Arun District Council
Arun Civic Centre
Maltravers Road
Littlehampton
West Sussex BN17 5LF
Planning & Building Control General Enquiries
Tel: (01903) 737756 Fax: (01903) 730442
Dx: 57406 Littlehampton
Minicom: 01903 732765
e-mail: planning@arun.gov.uk
website: www.arun.gov.uk/planning

Application No: FG/196/21/HH
Site Address: 9 Telgarth Road Ferring BN12 5PX
Description of works: Erection of single storey side infill and rear extension, hip to gable roof extension to include 2 x side dormers, installation of front porch canopy and alterations to fenestration/openings.

Thank you for your internet representation made on 22nd December 2021 which has been recorded as an objection with the comments as follows:

A 04

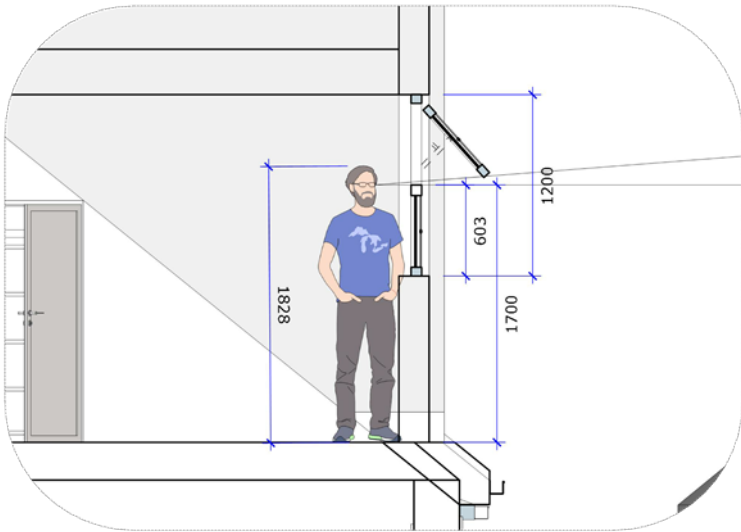
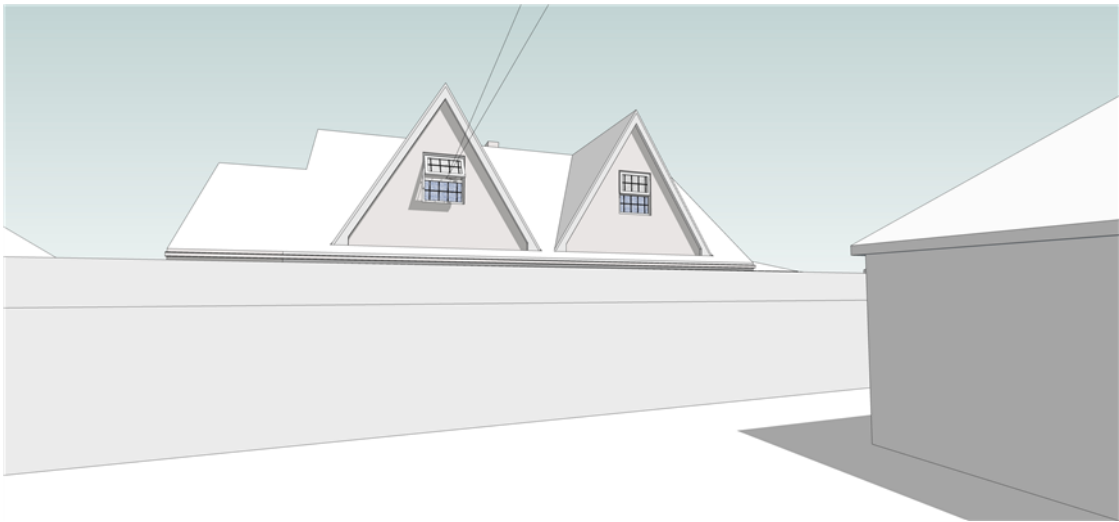
Whilst it is emphasised on sheet A4 that using the applicants floor to window opening of 1700mm, and person height of 1828mm, the field of view is restricted, clearly any small variation to these figures would significantly affect the sightline
